## Revisions for Short Plat SUB17-013

This is an update to the application for a short plat to the property located at 9740 SE 35<sup>th</sup> Place. The new short plat will consist of 3 individual lots and a Tract A, totaling 104,015 s.f., and will be called the Blue-Place Short Plat. The property currently consists of 2 adjacent parcels owned by On The Rock 98040, LLC. Parcel 072405-9009 is 100' wide x about 680' deep has several existing structures, including a single family residence. Parcel 072405-9010 is 50' wide x about 720' deep and also has several existing structures, including a boathouse and a dock. These 2 properties and the adjacent properties are located in the R-9.6 Zone. Please see the Project Narrative, dated July 12, 2017 for the complete referencing and details of the original submittal.

**Project Response** to the Review Comments letter, dated March 8, 2018.

SHEET 1
PRELIMINARY ENGINEERING
 BLUE SHORT PLAT
 9740 SE 35th PLACE, MERCER ISLAND, WA 98040

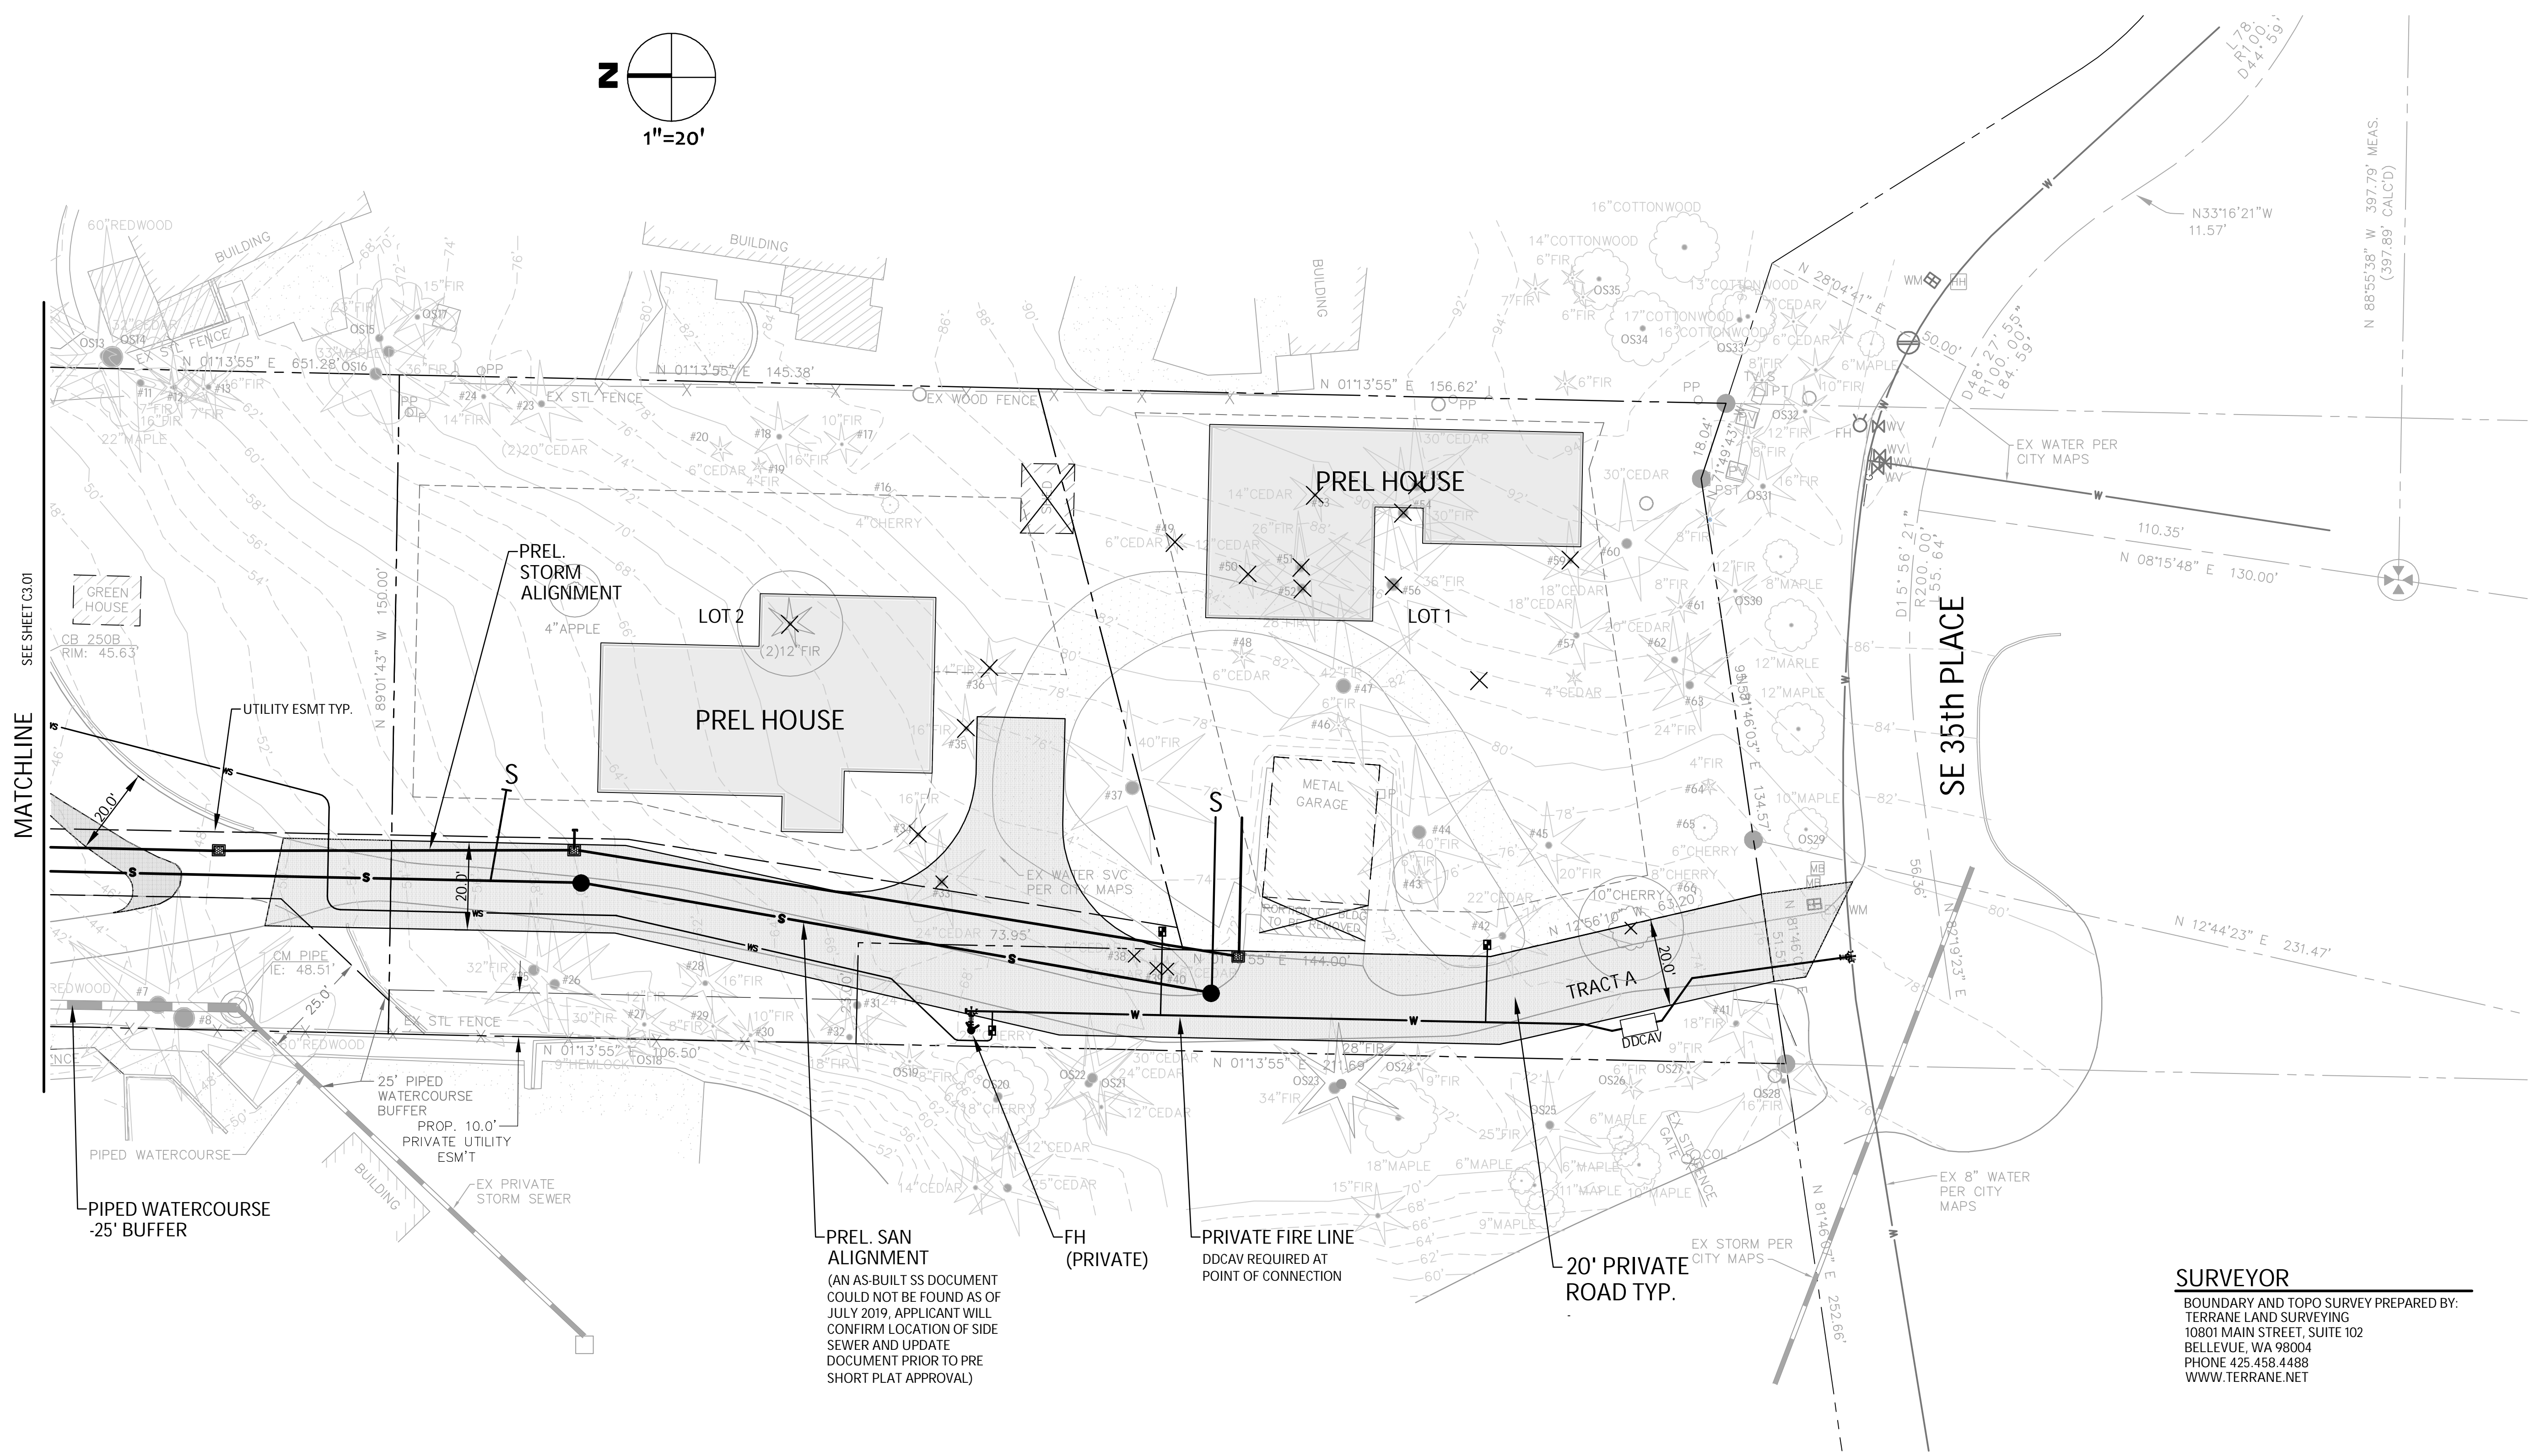
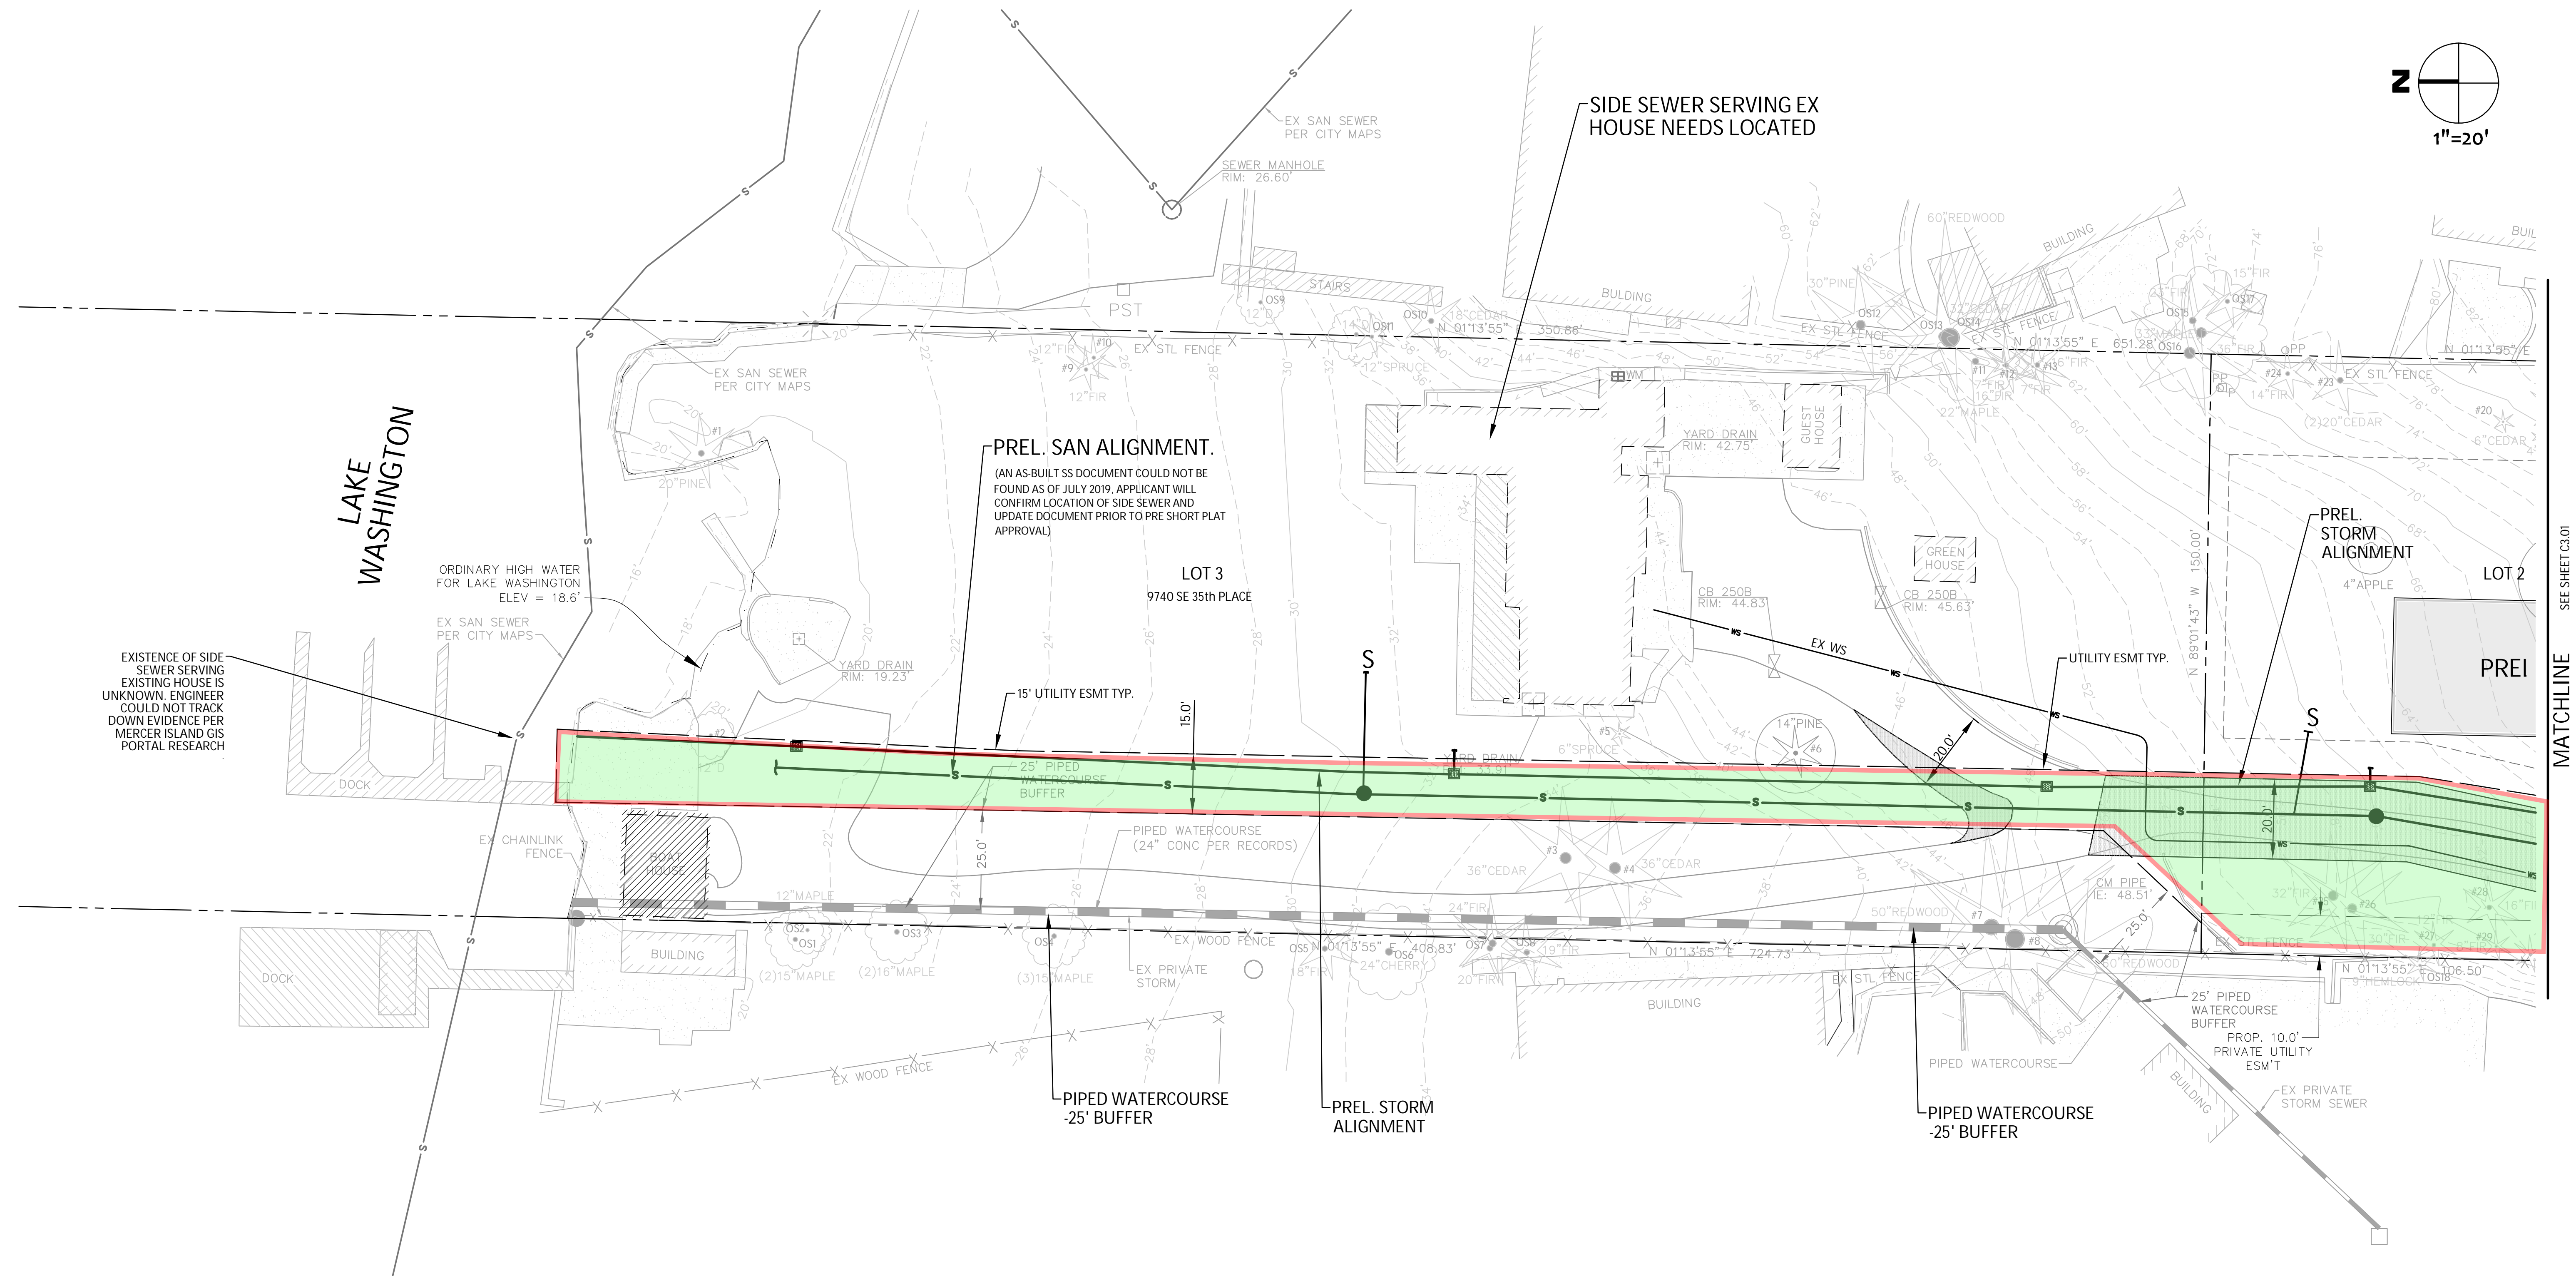
1. The engineering comments by Ruji Ding have been addressed by Duffy Ellis at Civil Engineering Solutions (CES). Revised Civil plans are being submitted.

1. The tree drip-lines have been shown on the Civil Engineering Plans and the Plat Survey Plans as requested.
2. All the trees have been numbered according to the Arborist's report.
3. The Arborist report has been updated by the Arborist, Shoffner Consulting as
